Application no: **3/2023/0659**

Address: **Land on the south side of Ridding Lane (Broad Lane) Whalley adj  
Sewage Works**

Proposal: **Change of use of agricultural land to exercise/play area for dogs.  
Erection of secure fencing and wooden shelter/rest area. Construction of  
limestone/gravel area for vehicle drop-offs and non-designated parking using  
existing gates. Pursuant to variation of condition 4 (number of dogs allowed on site)  
on planning permission 3/2018/1054 to allow up to 50 dogs.**

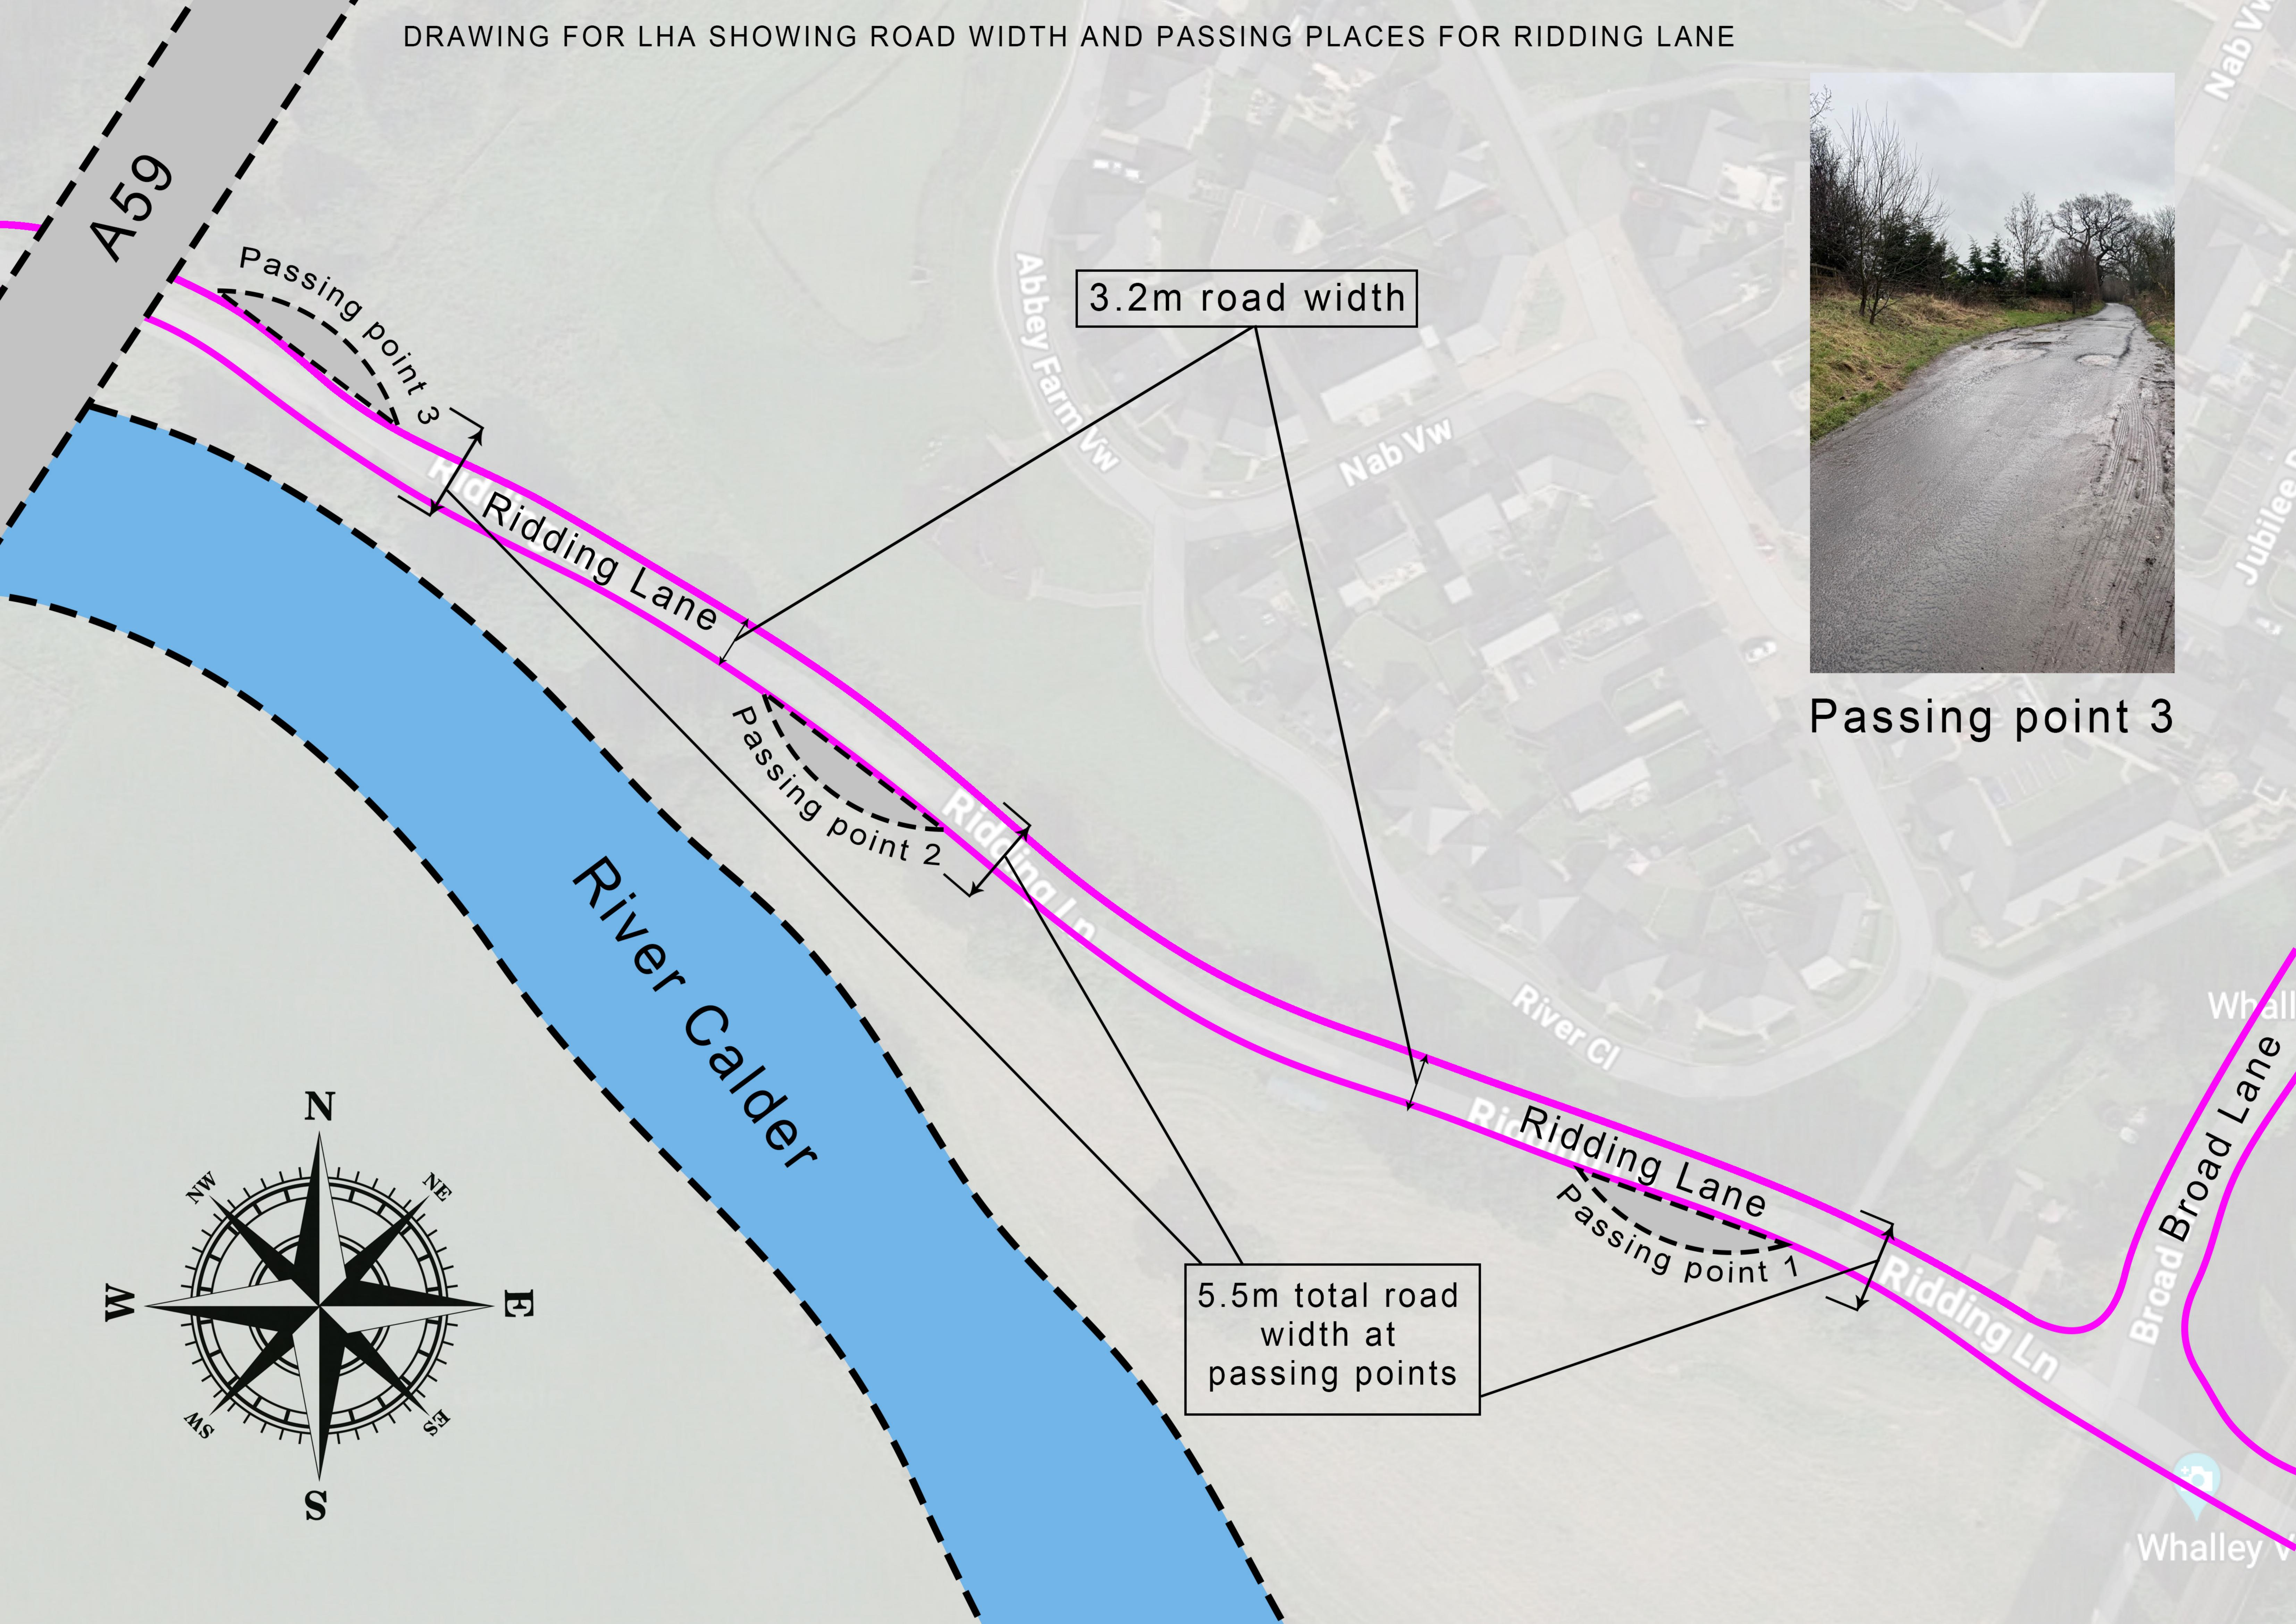
The LHA firstly require, following the proposed intensification of use, a drawing to be submitted showing the width of the unadopted access track named Ridding Lane to the site. The LHA require this to ensure that there are adequate passing places for vehicles to wait in along the single tracked lane, should two vehicles meet.

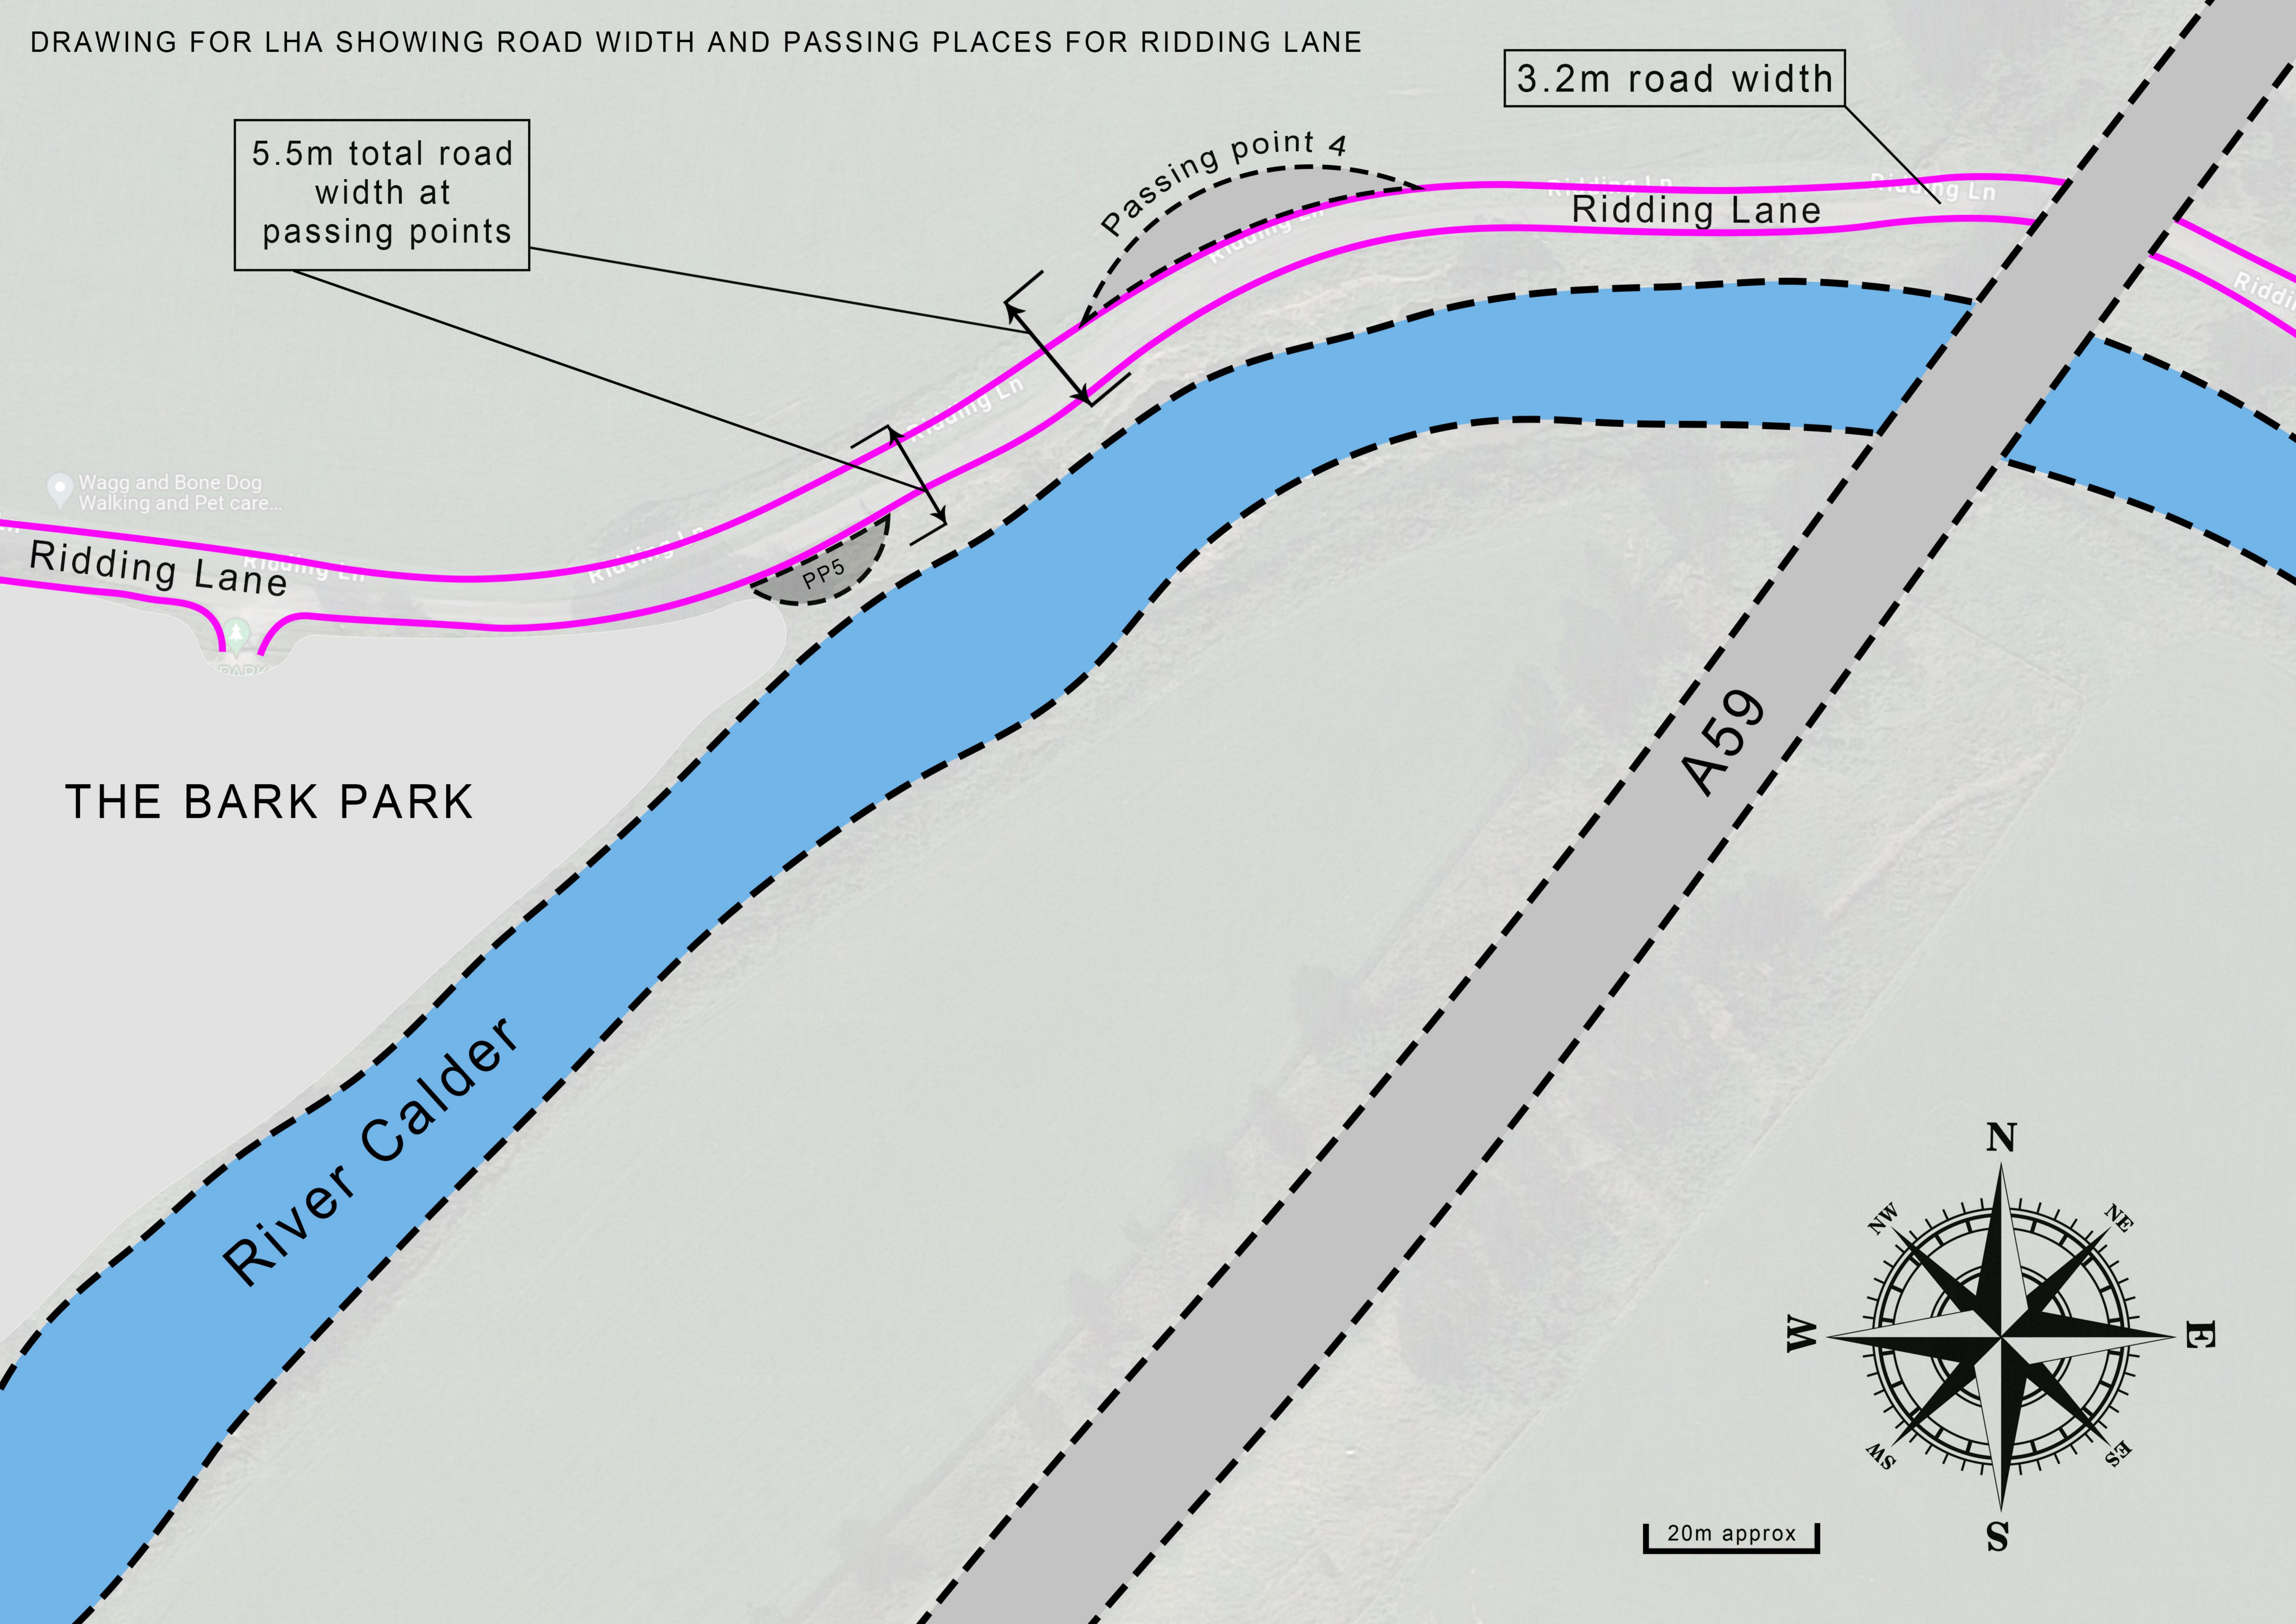
A visibility splay drawing should also be submitted for the junction between Ridding Lane and Broad Lane. The LHA remind the Agent that the junction is required to provide visibility splays of 2.4m x 25m in both directions.

Kind regards, Janet Sutton, Owner / Manager, THE BARK PARK Limited PARKING PLAN FOR THE BARK PARK, RIDDING LANE WHALLEY

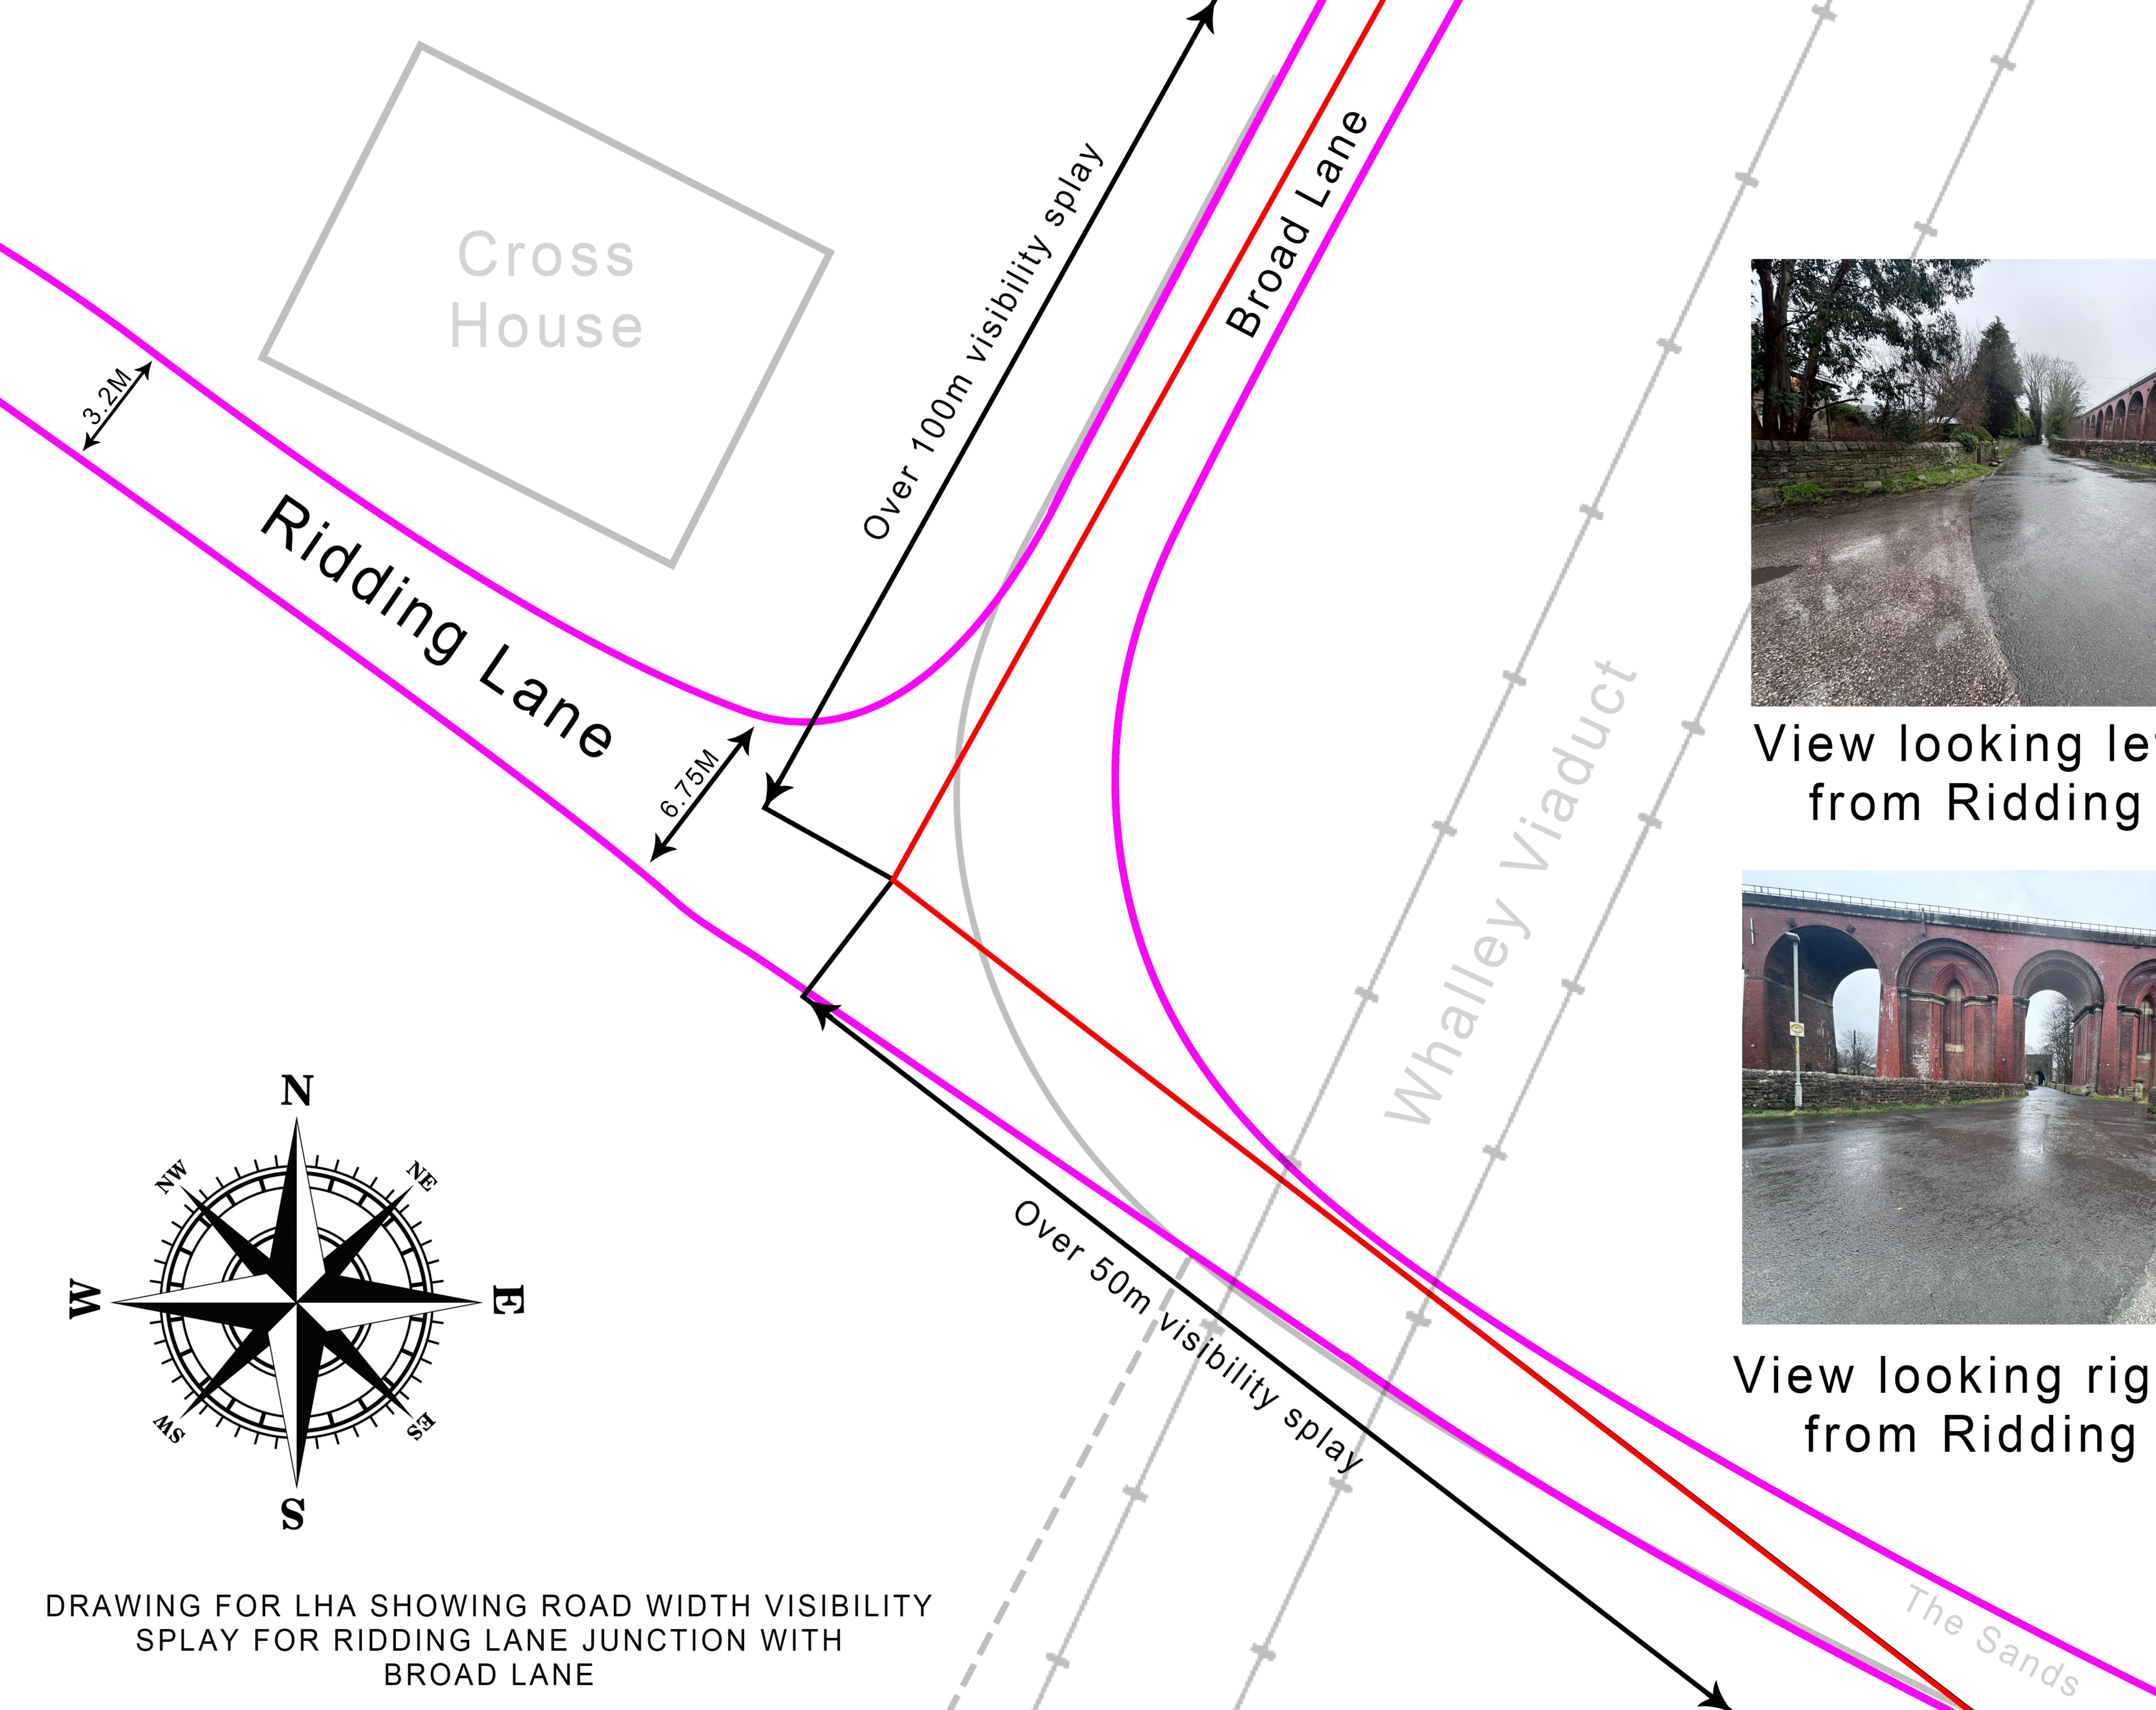
This information is required to gain an understanding on the number of trips the site is likely to generate and should be complimented by a parking plan following the likely intensification of use. This is to ensure there is adequate parking provided internally to cater for staff and customer numbers with any overspill parking onto Ridding Lane being unacceptable with it obstructing the use of the Public Right of Way (Public Footpath FP0345020).
